DEVELOPMENT REVIEW BOARD APPLICATION

**RE: FINAL SIGN OFF OF EPC SITE PLAN
(PROPOSED 30 DWELLING DEVELOPMENT)
TRACTS 27A-1 AND 27A-2 OF TAYLOR RANCH, REDIVISION
OF TRACT 27A INTO TRACTS 27-A-1 AND 27-A-2 OF THE
PLAT OF TRACTS 27-A, S-1, S-2, AND S-3 TAYLOR RANCH,
SITUATED WITHIN SECTIONS 23, 25 AND 26 T11N R2E, BLOCK 0000,
LOCATED AT THE NORTHEASTERN CORNER OF THE
INTERSECTION OF MONTAÑO ROAD NW AND TAYLOR
RANCH ROAD NW (4701 MONTAÑO ROAD NW),
APPROXIMATELY 3.4 ACRES (E-11-Z AND E-12-Z)**

EPC CONDITIONS OF APPROVAL:

ENGINEER'S SEAL RONALD R. BOHANNAN P.E. #7868	SARANAM AT 4701 MONTANO RD NW	DRAWN BY BF
	SITE PLAN	DATE 7/28/2020
TIERRA WEST, LLC 5571 MIDWAY PARK PLACE NE ALBUQUERQUE, NM 87109 (505) 858-3100 www.tierrawestllc.com	SHEET # C1	JOB # 2019080

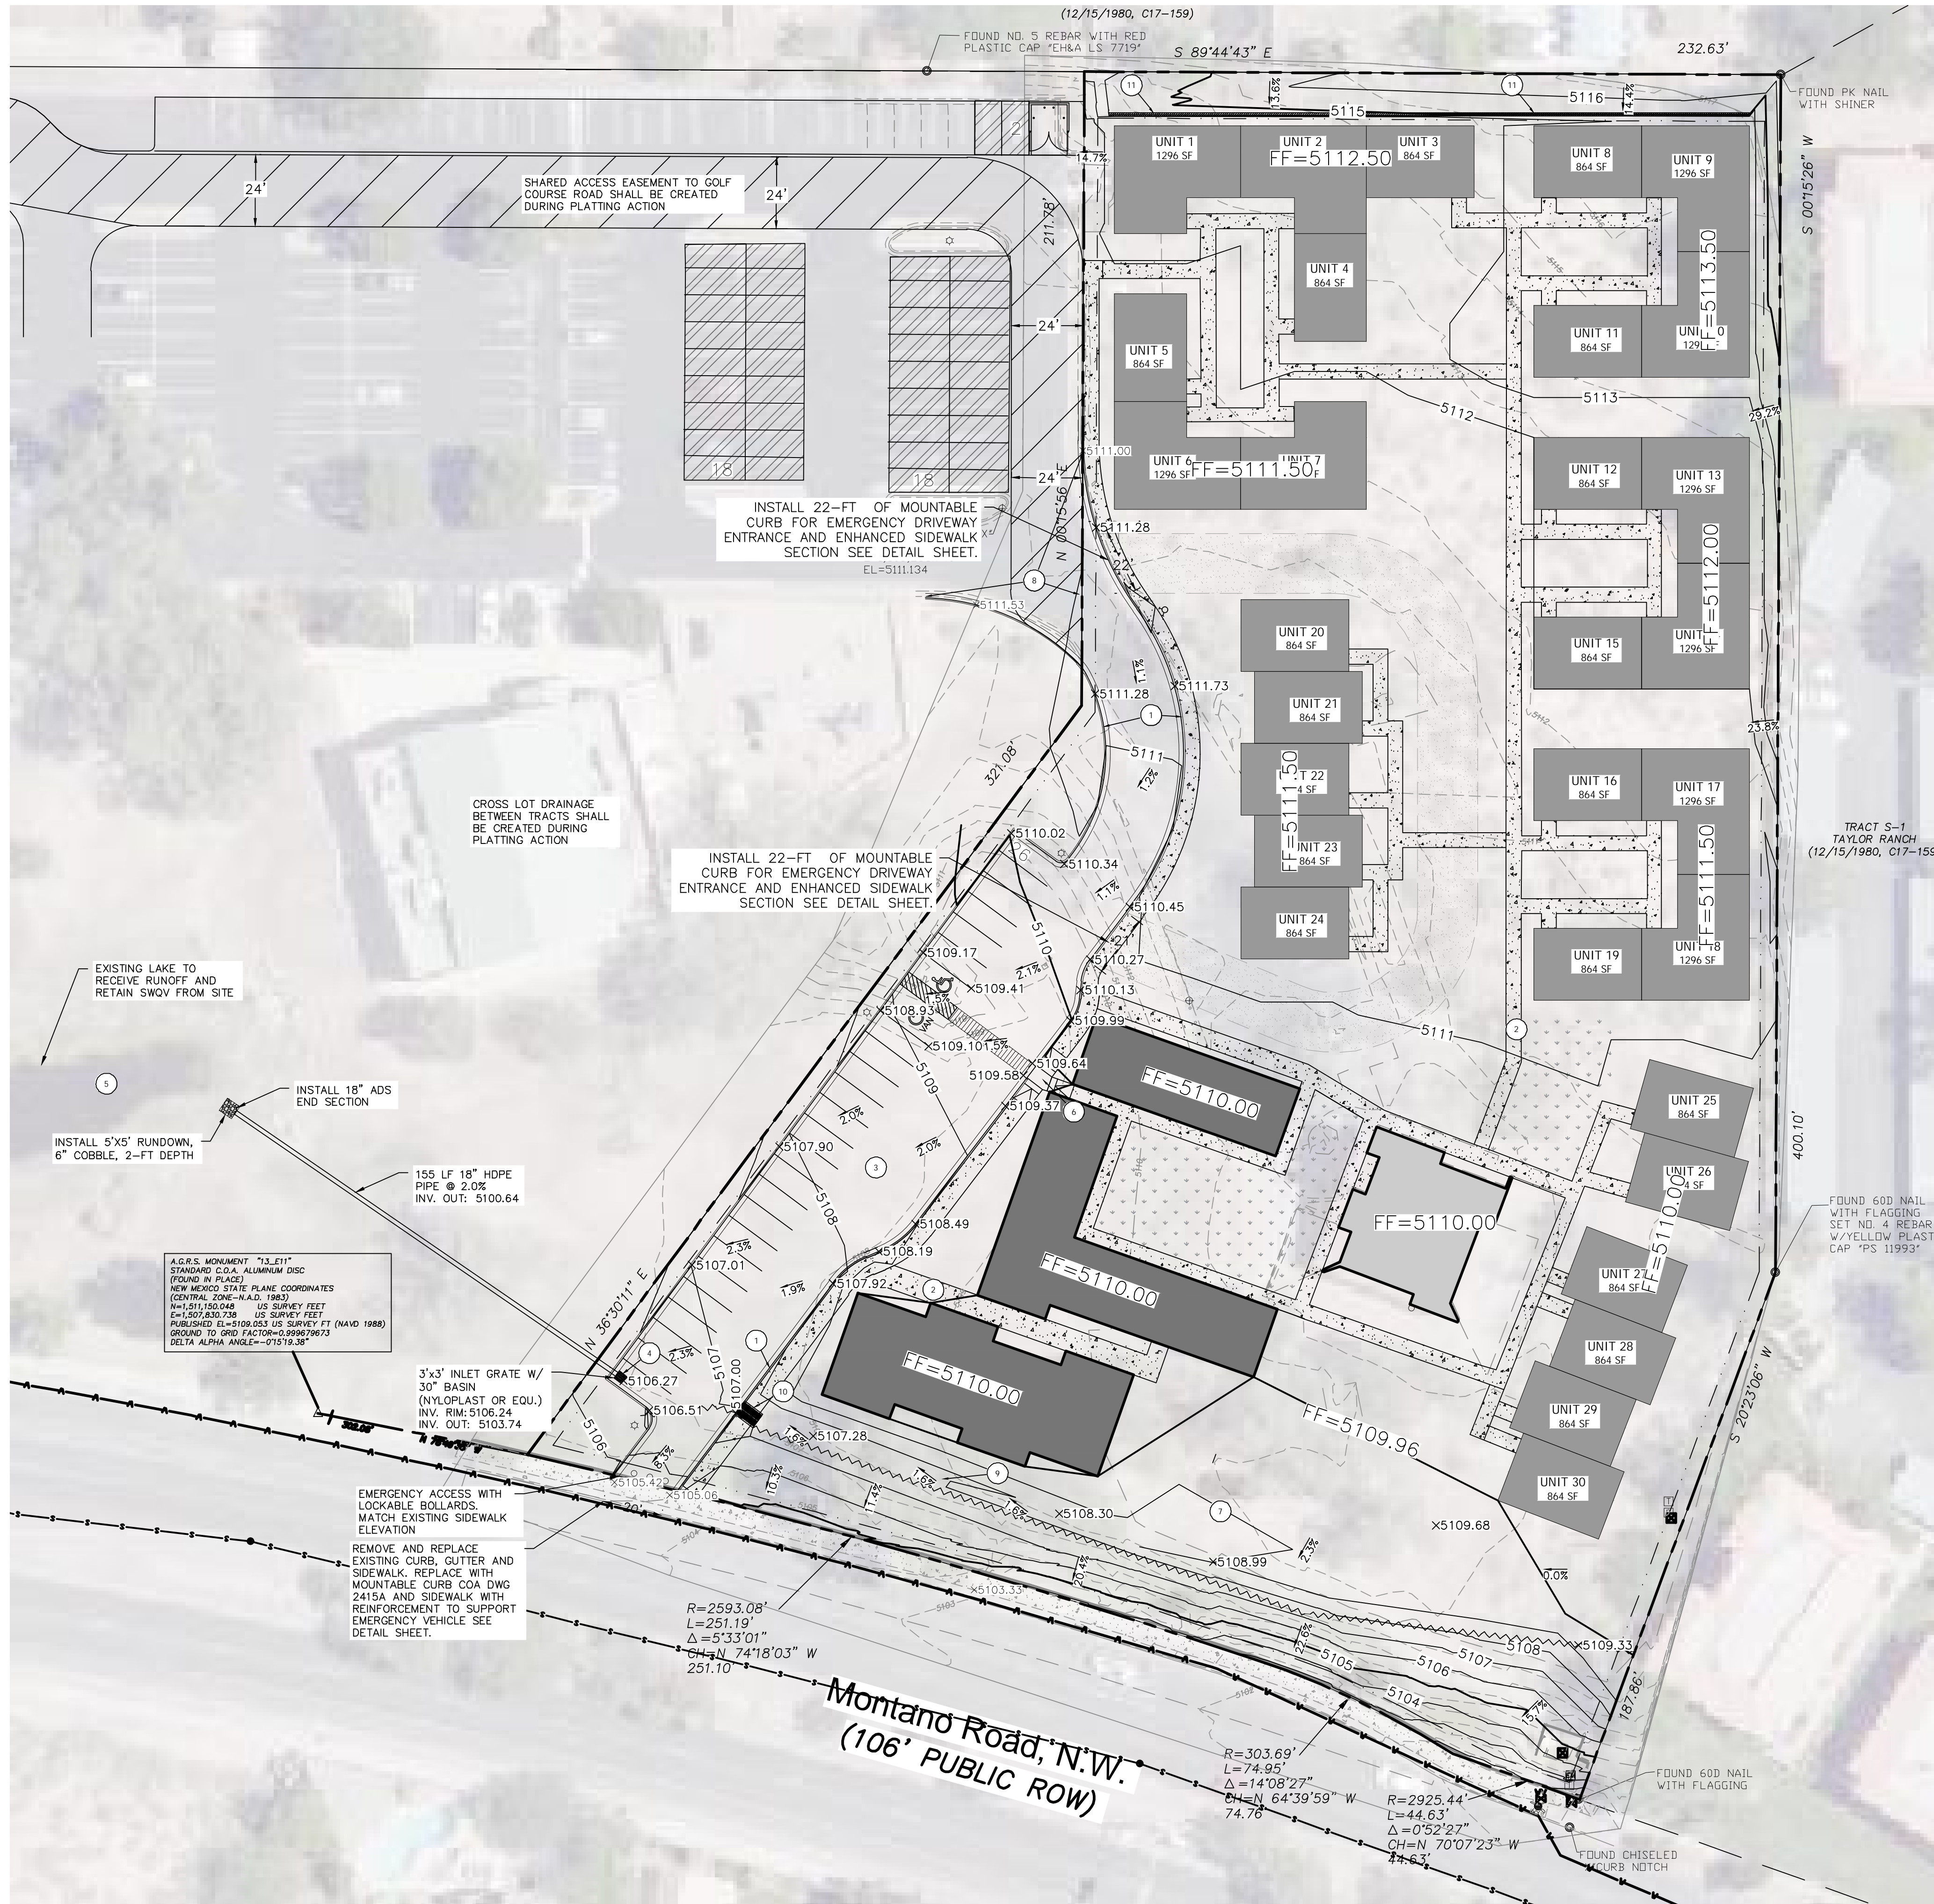
- A. The motorcycle parking calculations shall be deleted if MC parking is not being provided [Note: it is not required pursuant to IDO Section 14-16-5-5(D)].

- B. Clarify if the bicycle parking provides 4 spaces or 2 spaces each.

4. Pedestrian Access: The applicant shall provide better pedestrian access from the dwelling units to sidewalks and transit stops along both Golf Course and Montano Roads in the form of walkways with trees and/or shading that meet the applicable IDO standards of Sections 14-16-5-3 and 14-16-5-6.

- A. The legal description shall include Tract 27A-1.
- B. The subject site's zoning shall be listed.
- C. Revise the sheet index.
- D. The same number for building square footage shall be used on Sheet C-1 and on the landscaping plan.

- E. Top plan view appears to incorrectly show the access to Golf Course Road where this section of road to the west is shown as "Taylor Ranch Drive". **Corrected**

- F. In general, a 6-foot connection in lieu of a 5-foot connection is required to tie into Montañó Road from main building entrance and from main building entrance to the handicapped spots. However, for an MX zone, follow IDO requirements for sizing of walkways based upon square footage of buildings. **6-ft sidewalk connection provided**

Response: Motorcycle parking calculations removed

Response: 16 total parking spaces with 4 racks offering with 4 spaces.

Response: Trees added to walkways where possible. 6-ft sidewalk connection provided to Montano public sidewalk.

Response: clarifications made to address comments A-D

SARANAM AT
 4701 MONTANO RD NW
CONCEPTIONAL GRADING & DRAINAGE PLAN

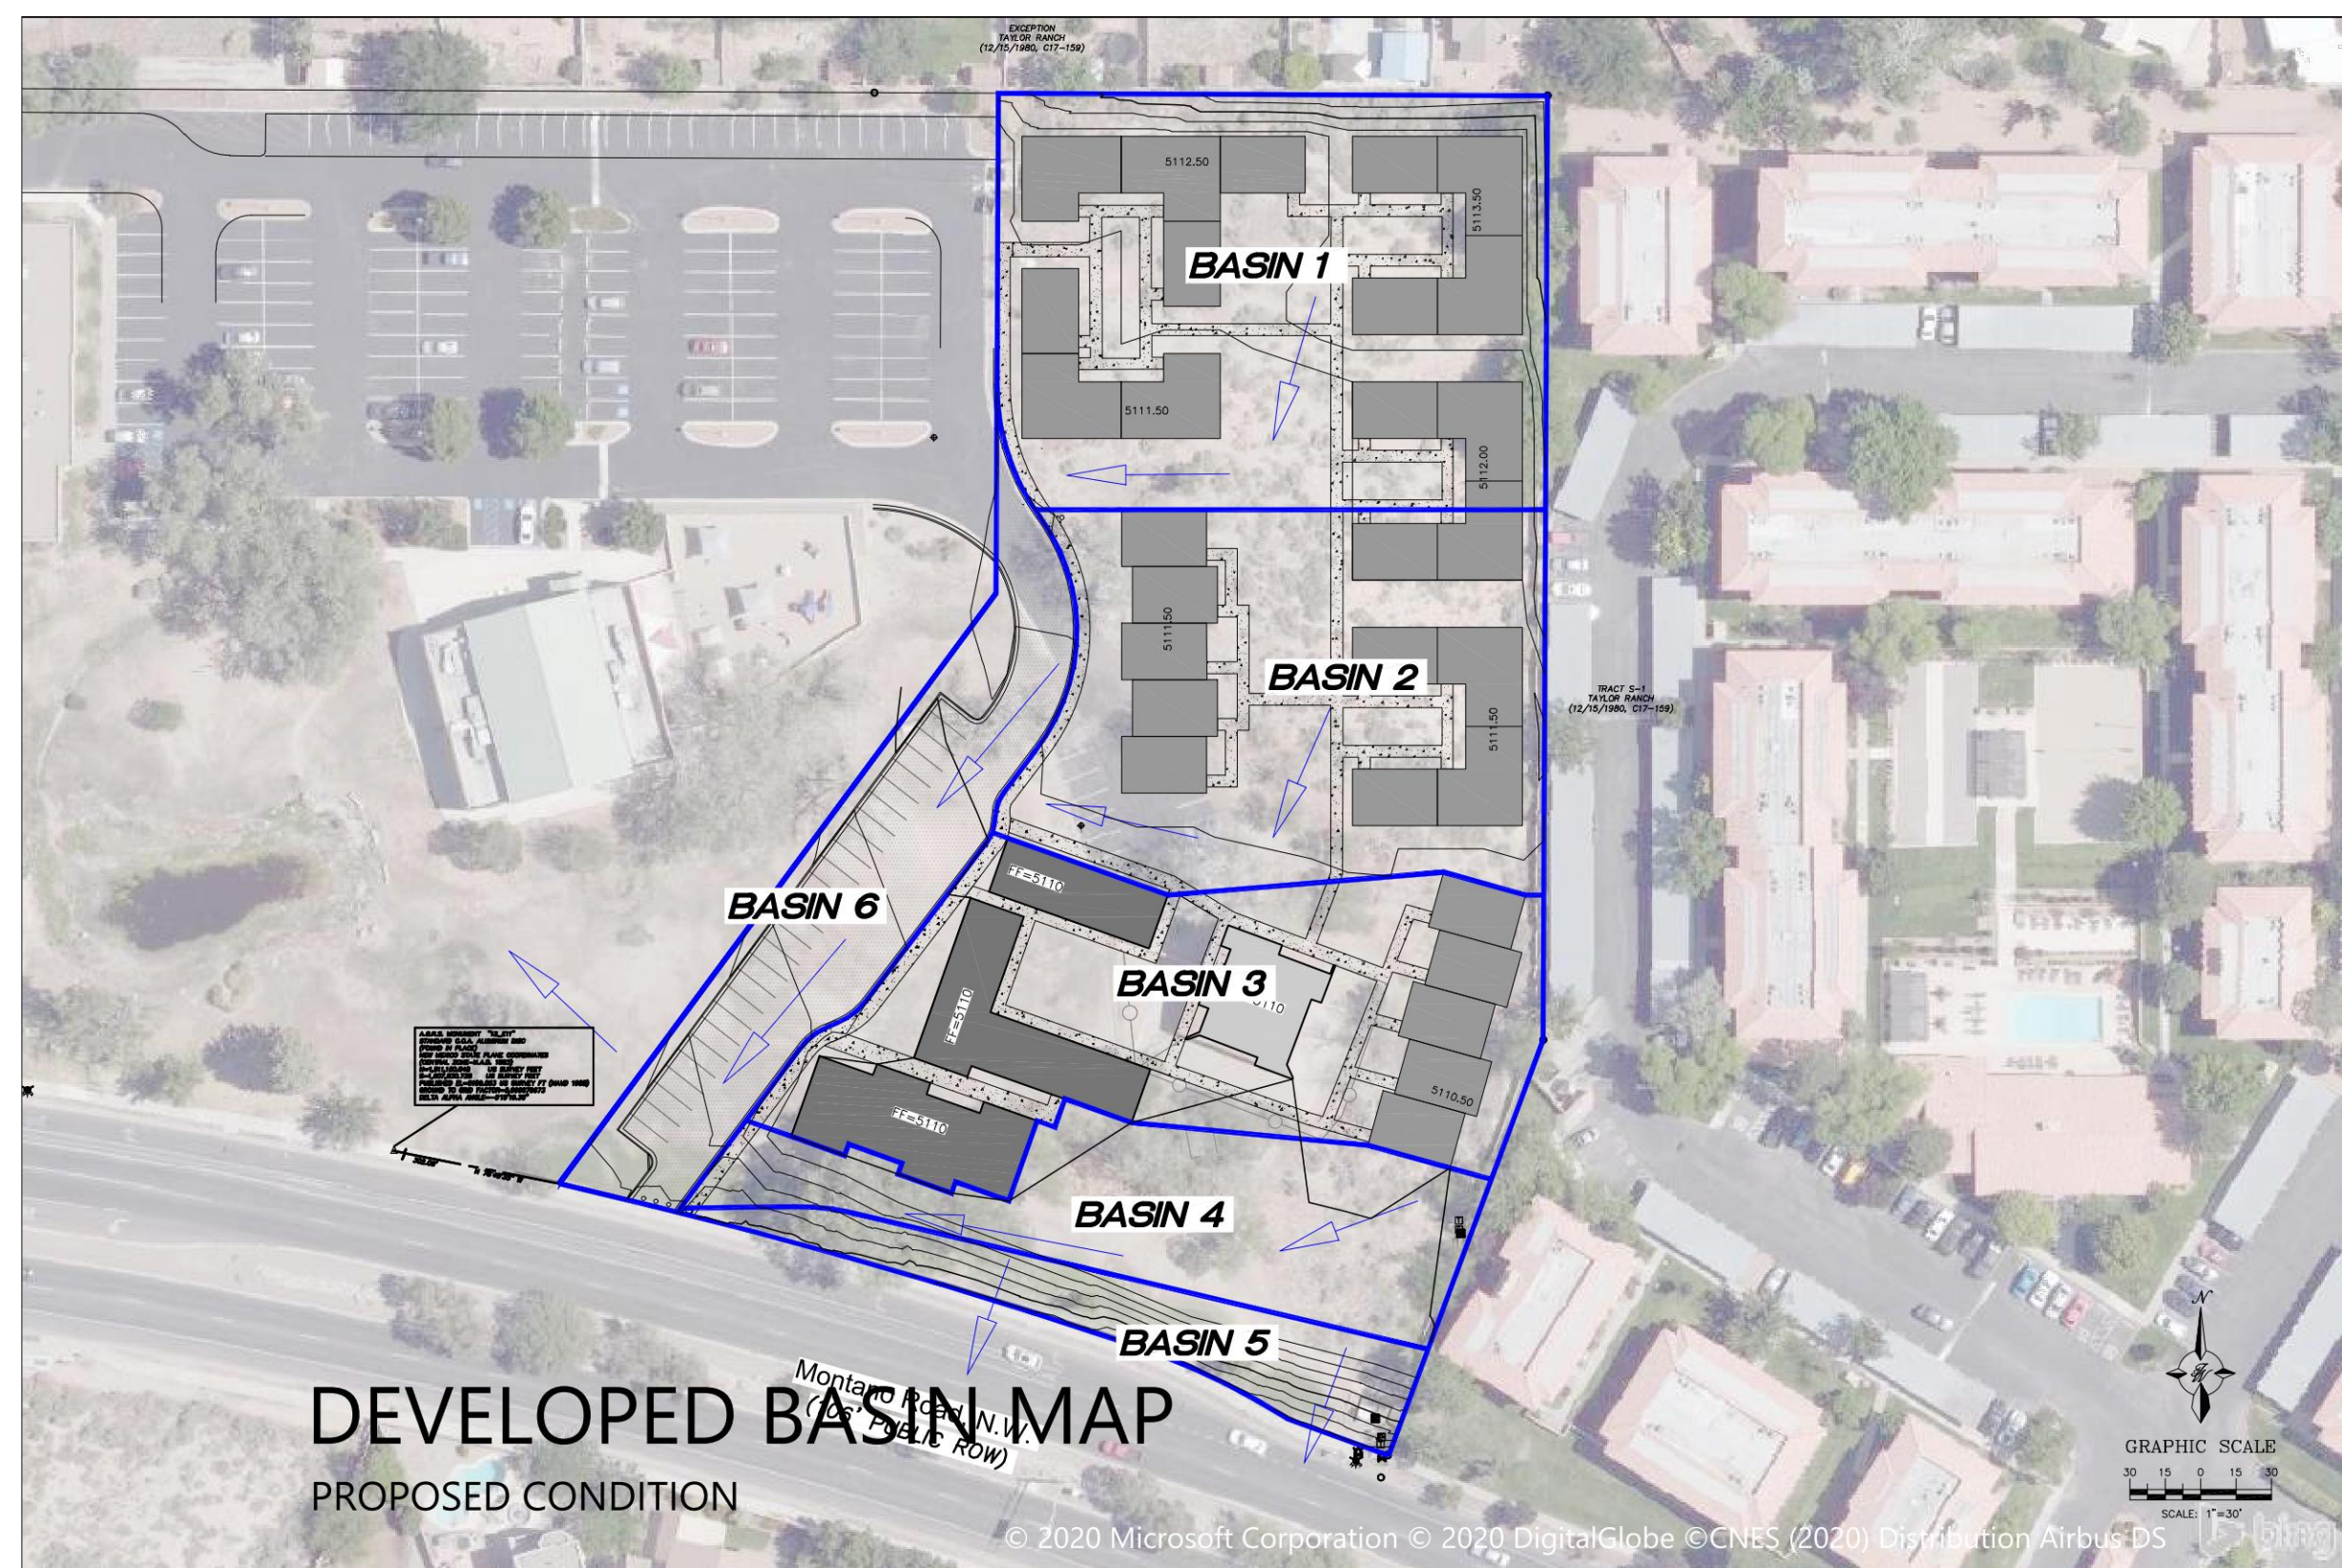
Curb notches shall be shown in the same locations as on the landscaping plan.

Response: Plans updated.
